Gro	Bowdens Silver Projectundwater Assessment R	t eview
Prepared for:	NSW Department of Planning and Environment (DPE)	19 December 2022

Middlemis H (2022). Bowdens Silver Project Groundwater Assessment Review (version 5). Prepared by HydroGeoLogic for NSW Department of Planning and Environment. 19 December 2022.

Figure 51 West-east Geological Cross-section through the Model

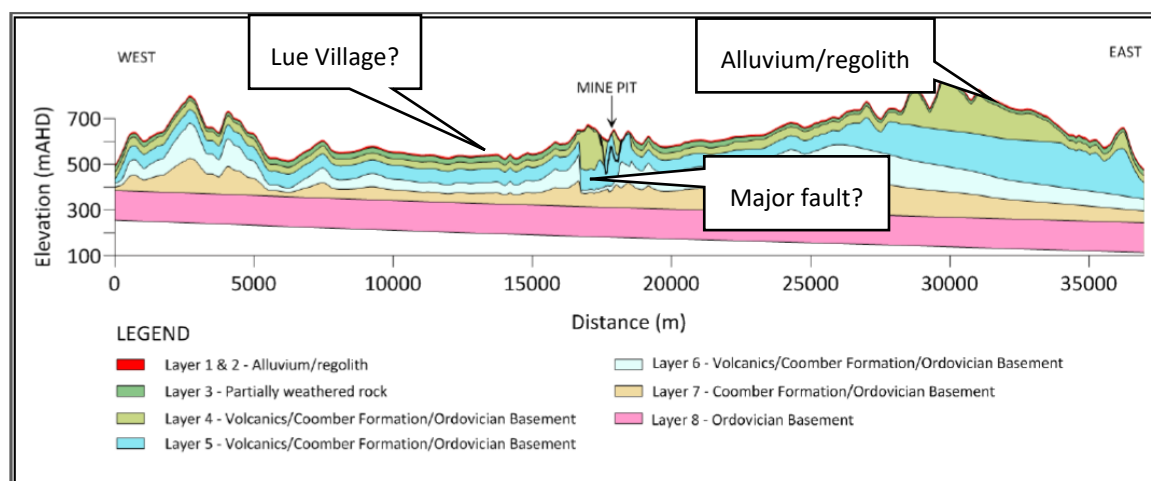
Figure 51 of the EIS groundwater assessment (Jacobs 2020, excerpt shown in Figure 2 below; shown as Figure 15 of Jacobs 2022) shows geological cross-sections that are based on regional data from the Western Coalfield Geological Modelling Project (NSW Dept of Resources and Energy), supplemented by mine site data. These figures show considerable layer deviations at the mine site, but there was no commentary provided to justify this representation as reasonably representing the geological system. For example, the role of the mapped fault structures is not discussed, although that could justify the mismatch between the site data and the regional data.

The Submissions report and Updated Groundwater Assessment ('UGA'; Jacobs 2021a) did not present any additional explanation, despite this issue being raised by the initial review as requiring corrective action. The Memorandum accompanying the UGA (Jacobs 2021b) does offer this response: "The perturbations to regional geological layering are left over from the early construction of the groundwater model prior to confirmation of the final mine design. The layering was to allow for simplification and versatility if an expansion of the preliminary mine design was to be adopted. It is noted that due to the adopted parameter zonation in the mining area, the perturbations are of little consequence to predictions of mine dewatering or associated groundwater drawdown and impacts."

Similar comments appear in Jacobs (2022), which effectively acknowledges (or does not disagree) that the layer deviations in the mine area are physically unrealistic. The layer deviations have not been justified on the basis of geology, as would be expected. The problem is that the layer deviations substantially offset and laterally juxtapose aquifer

layers with hydraulic conductivity (K) values that change by up to a factor of 6 across the deviation, although it is difficult to be definitive due to the compressed scale of the hydraulic property zones plot and the complex table of values (Jacobs 2022, Figure 18 and Table 9). The assertion that the perturbations would be 'of little consequence to predictions' is not objectively justified and is questionable, as outlined below, although it is acknowledged that the interpretations involved may be flawed due to the lack of detail provided in the reporting.

For example, with reference to Figure 2 above and Figure 3 below, layer 6 across most of the mine area is very thin, which creates a very low transmissivity unit across the base of the mine area (transmissivity ('T') is the product of thickness with hydraulic conductivity ('K'), and indicates the groundwater transmission capacity of the layer). The layer deviations applied have resulted in zones of a thin layer 5 in some areas (Figure 3), and thus very low T values where associated with low K values.
